Application by SP Manweb for an Order Granting
Development Consent for the Reinforcement to the
North Shropshire Electricity Distribution Network

Issue Specific Hearing on the Applicant's
Draft Development Consent Order
(dDCO)

COMMENTS BY THE EXAMINING AUTHORITY on the DRAFT DEVELOPMENT CONSENT ORDER

Diagram 2.2 Illustration of different Trident pole types

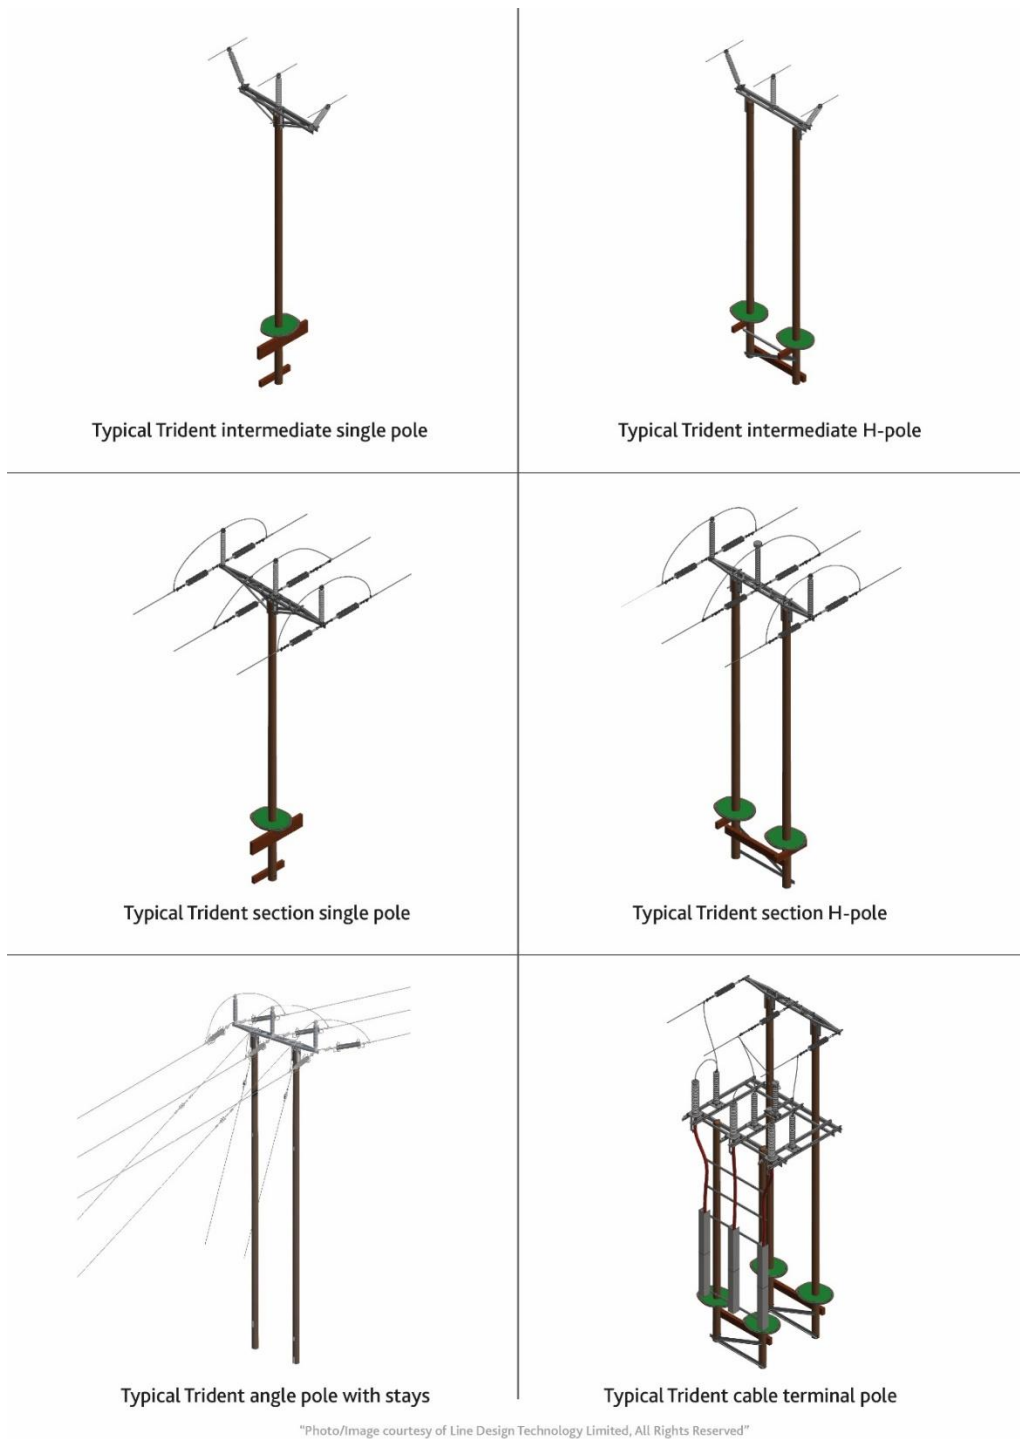
– Table 1 – the pole types listed in column 4 need to be referred to the Diagram 3.2 Illustration of Pole Types contained in Annex C REP2-007, and this diagram should be a certified document in Table 10 of Schedule 9.

- delete “Proposed Pole Schedule included as Appendix 3.1 to the Environmental Statement” and substitute “Diagram 3.2 Illustration of Pole Types contained in Annex C REP2-007”.

Document Title:
LIMITS OF DEVIATION SHEET 1 of 14

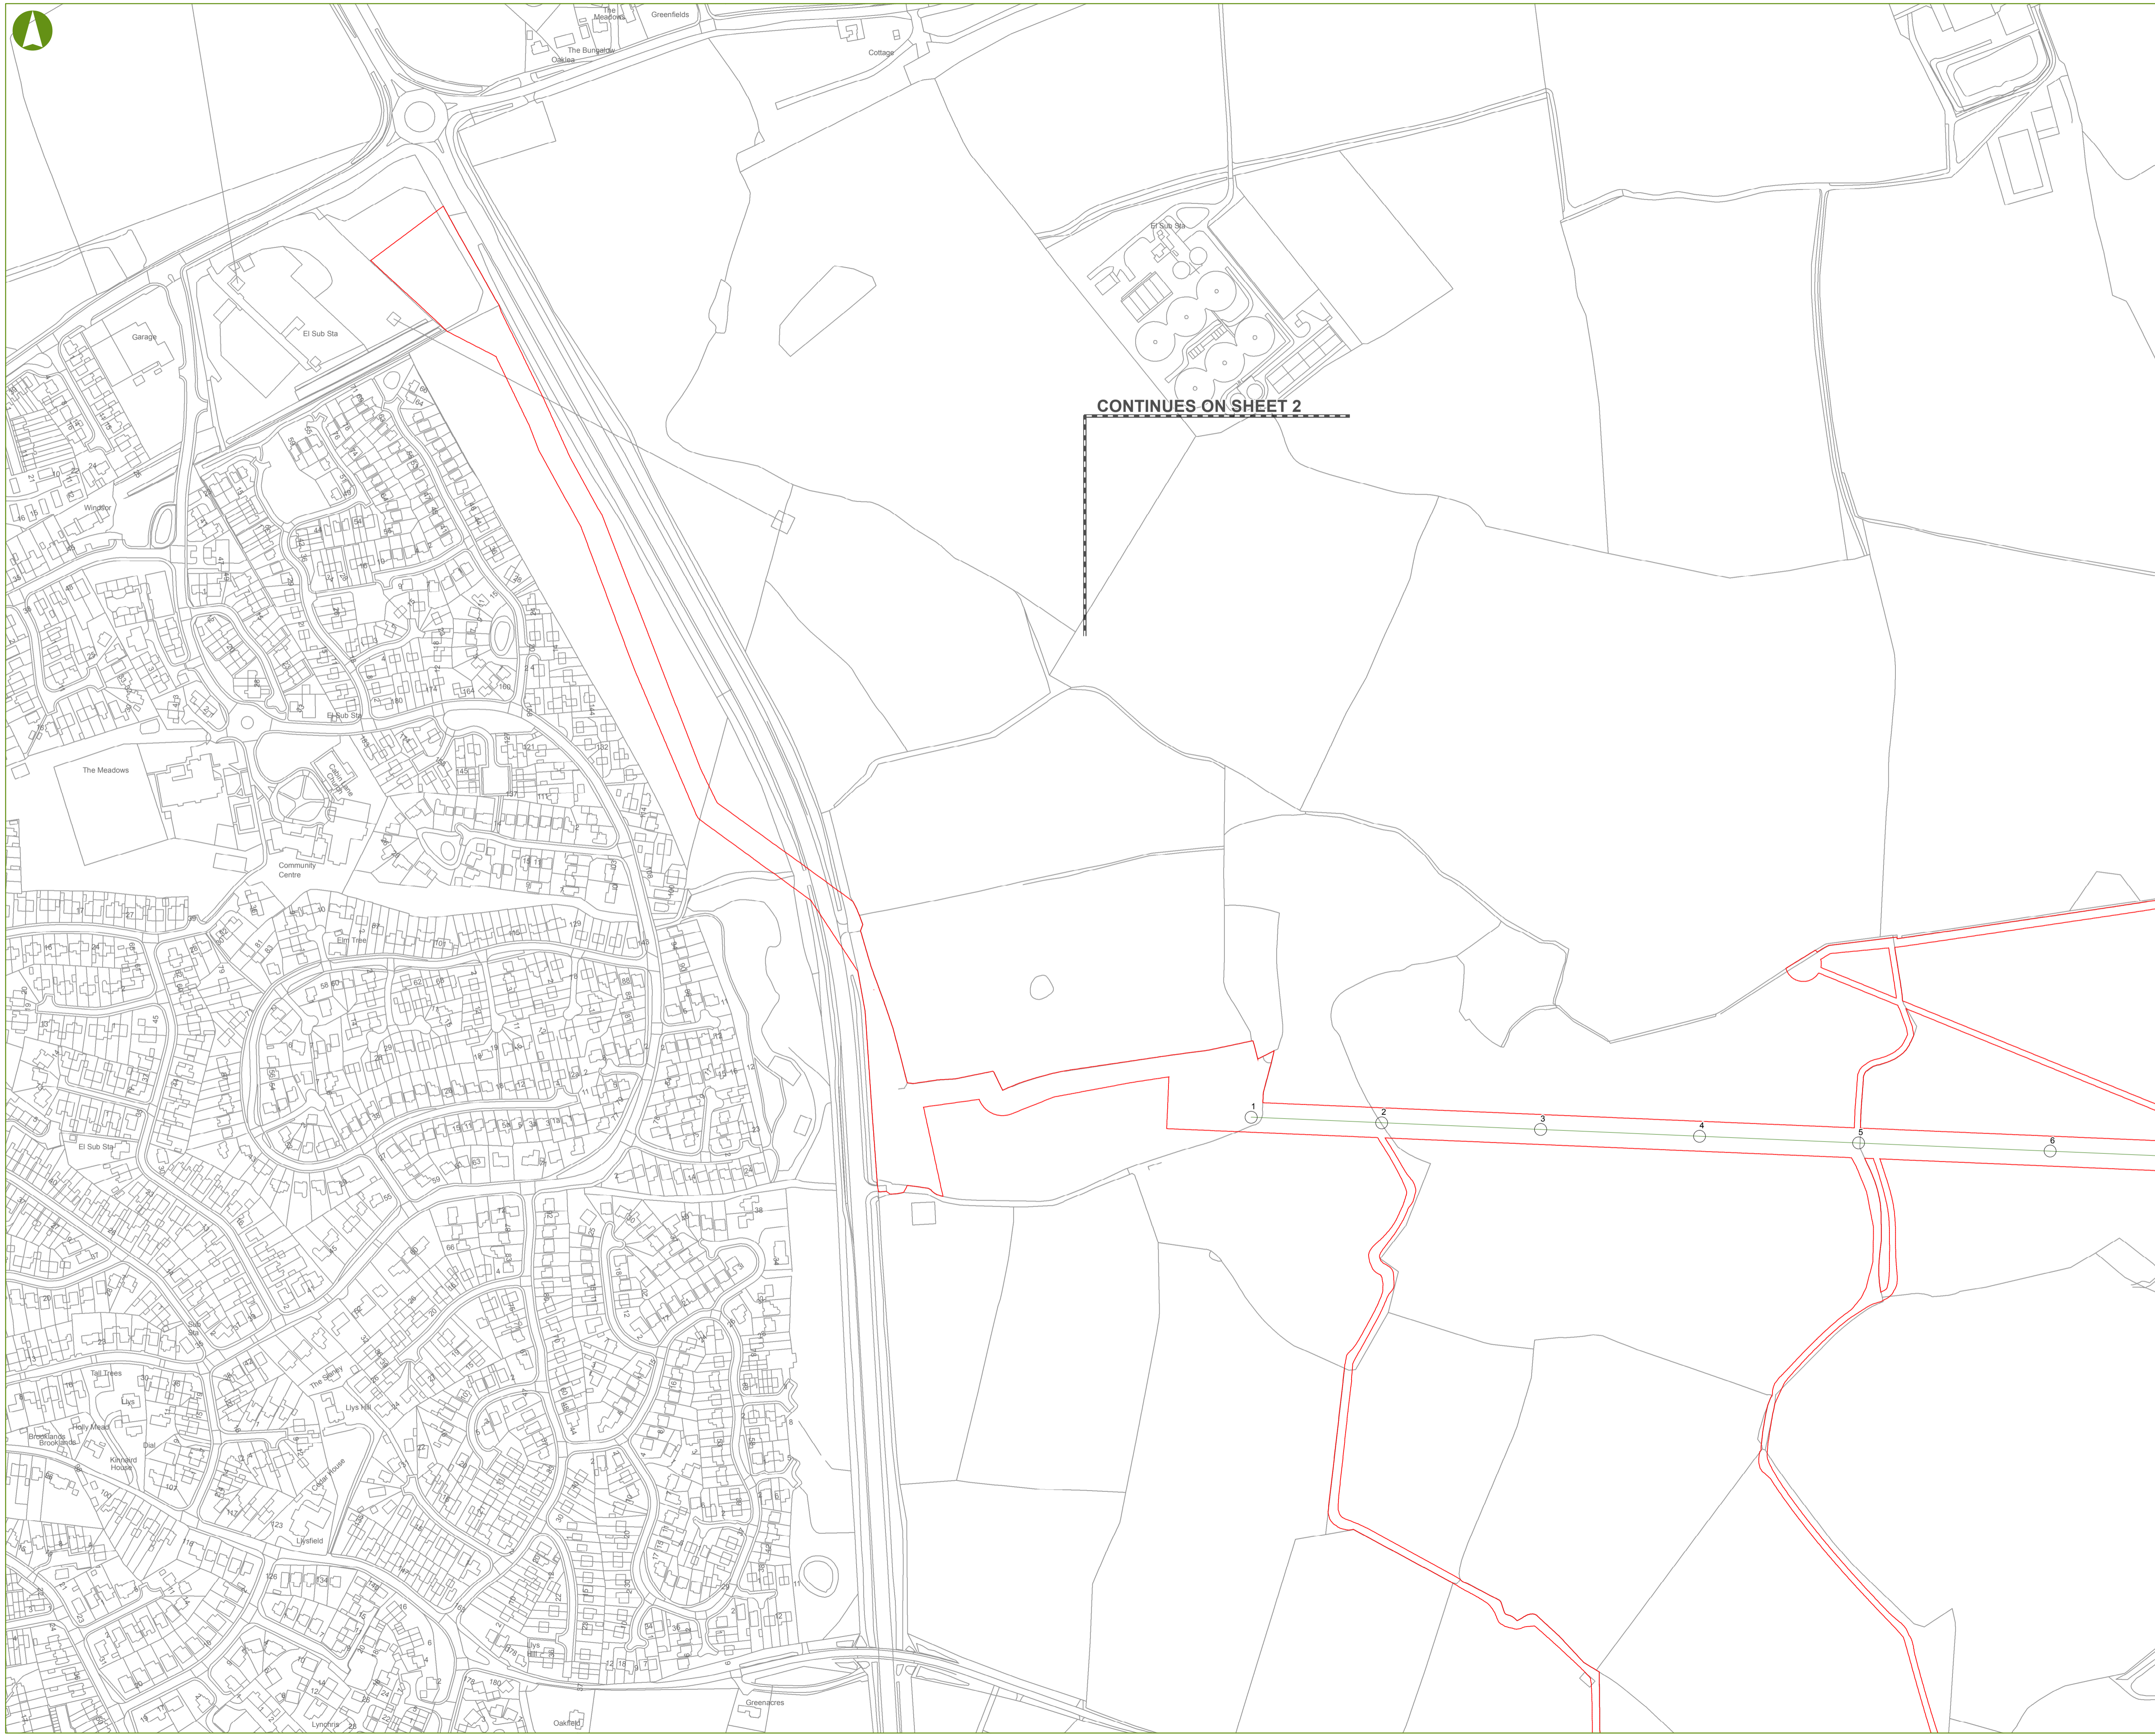
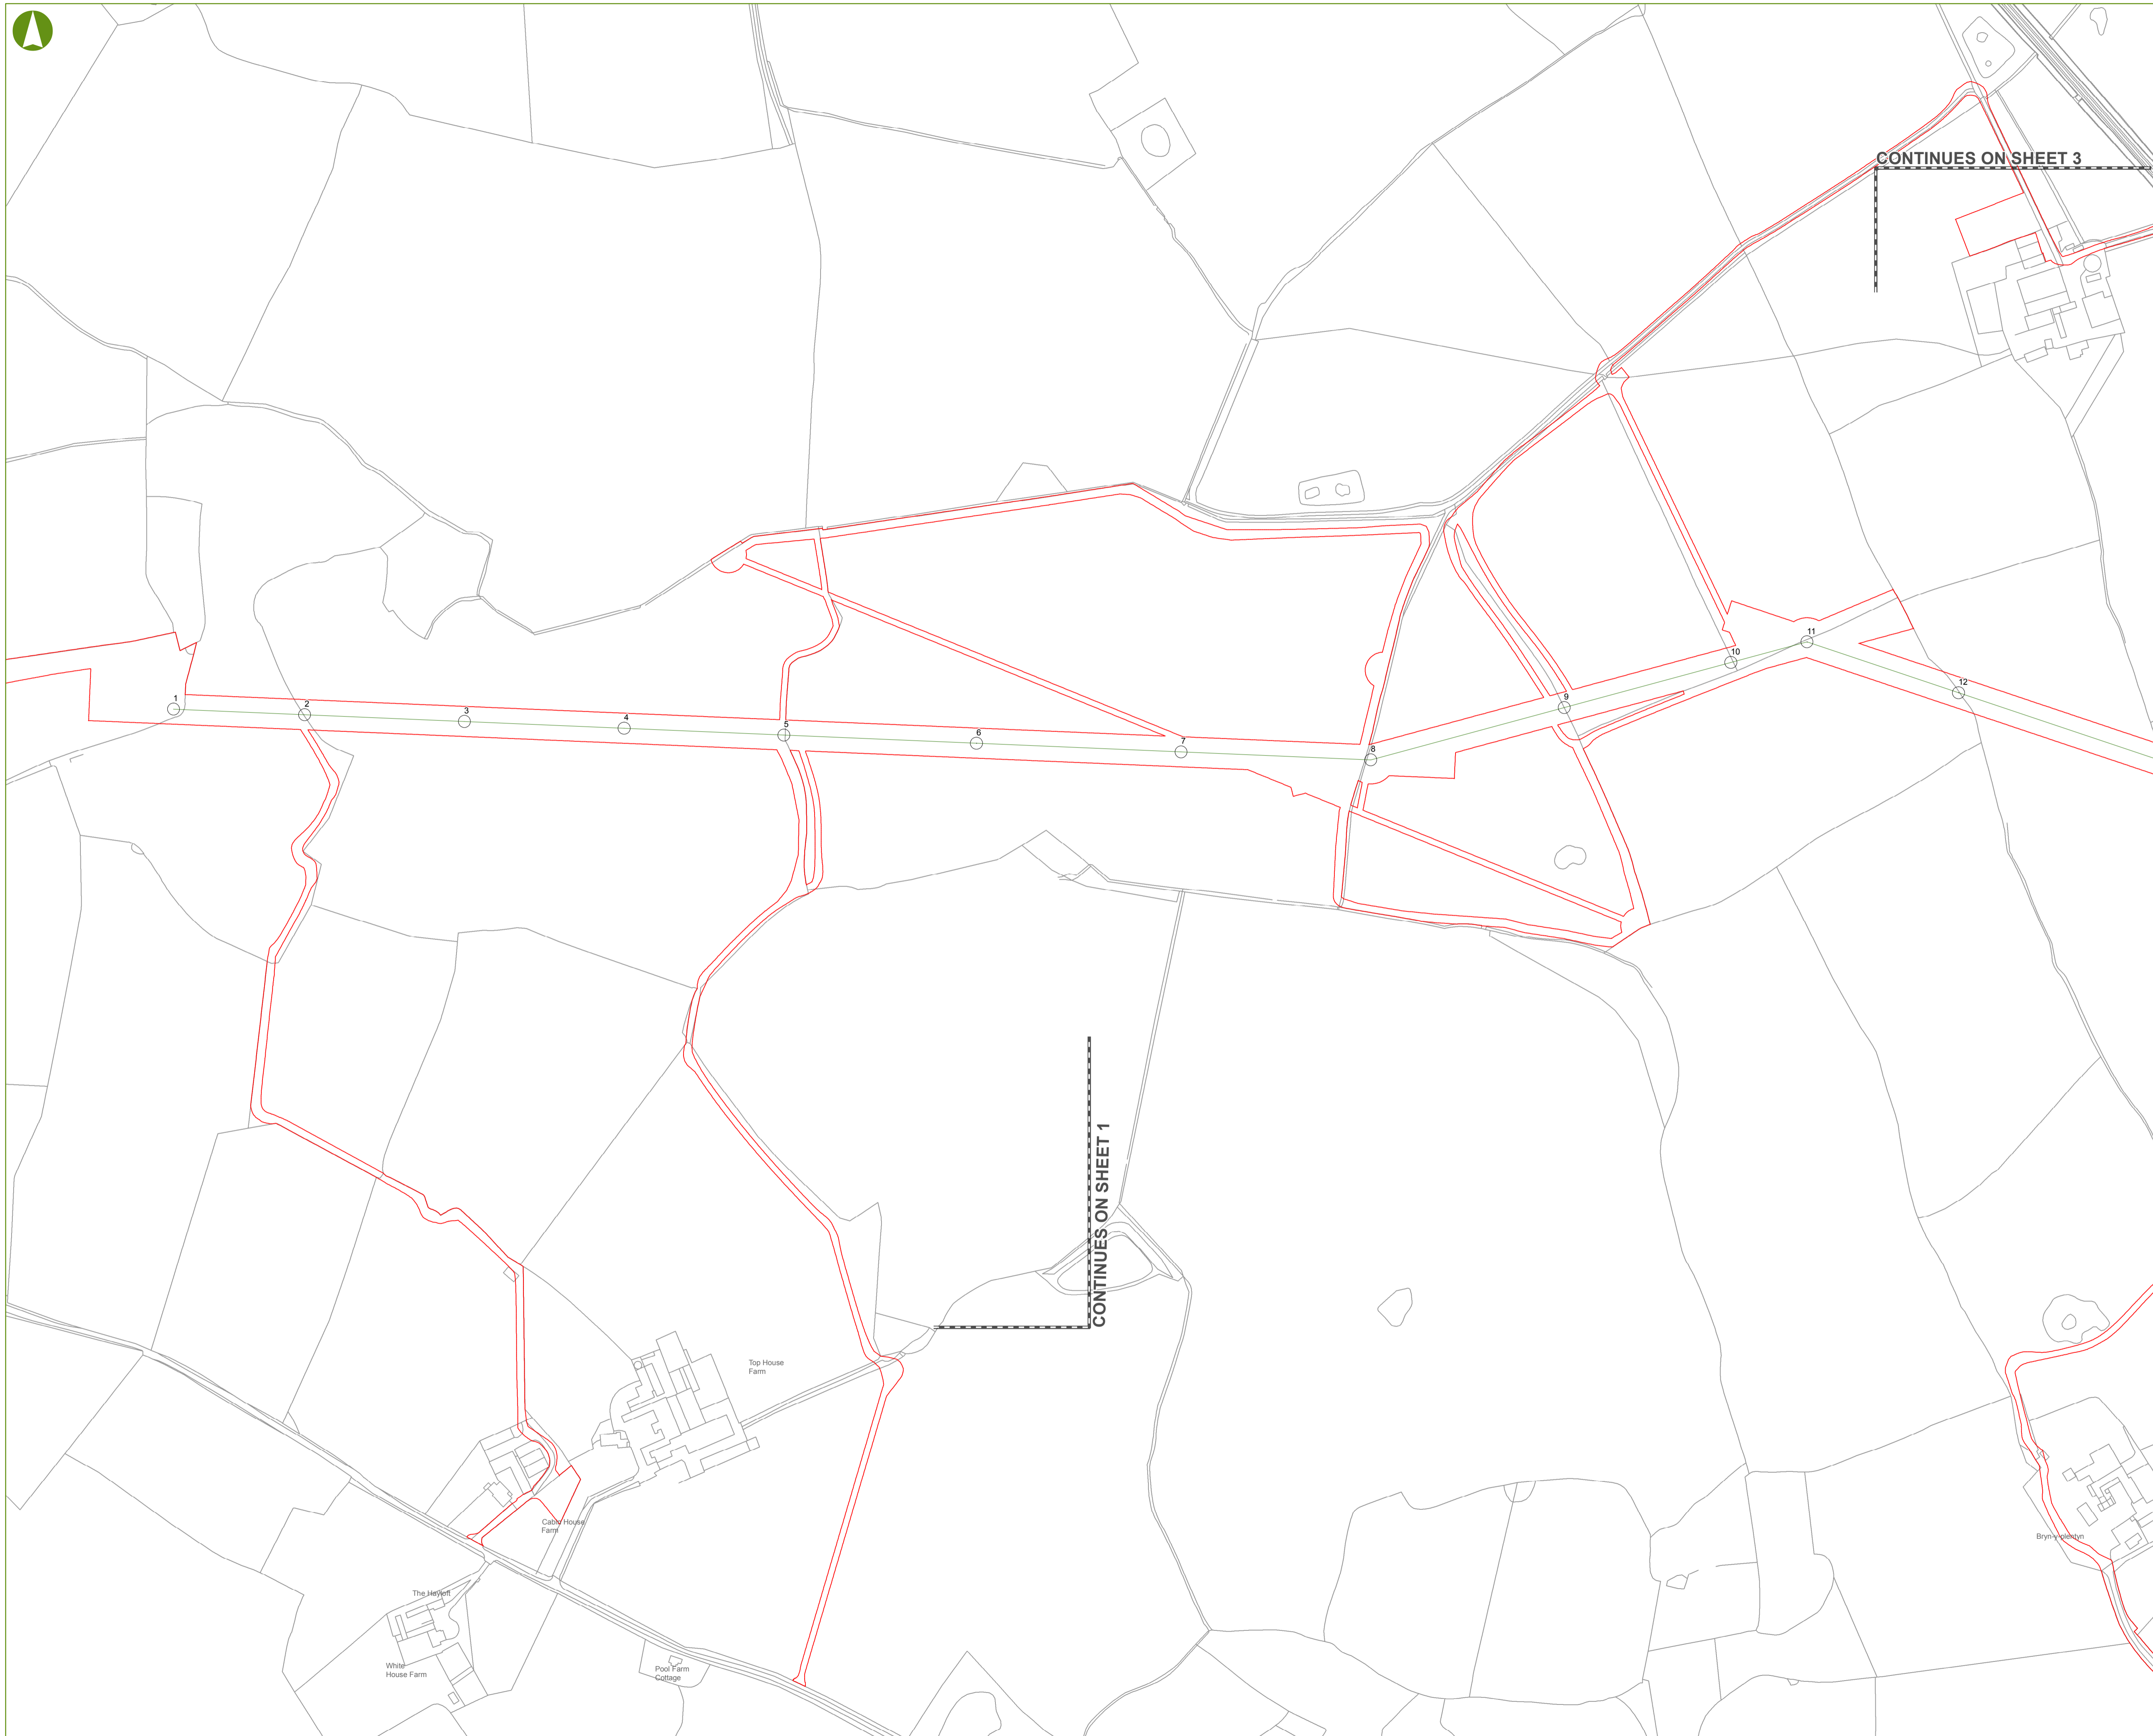
- check all documents required to be certified are included, for example Limits of Deviation Plans (AS-003) and Construction Access Location Plan (REP1-005).
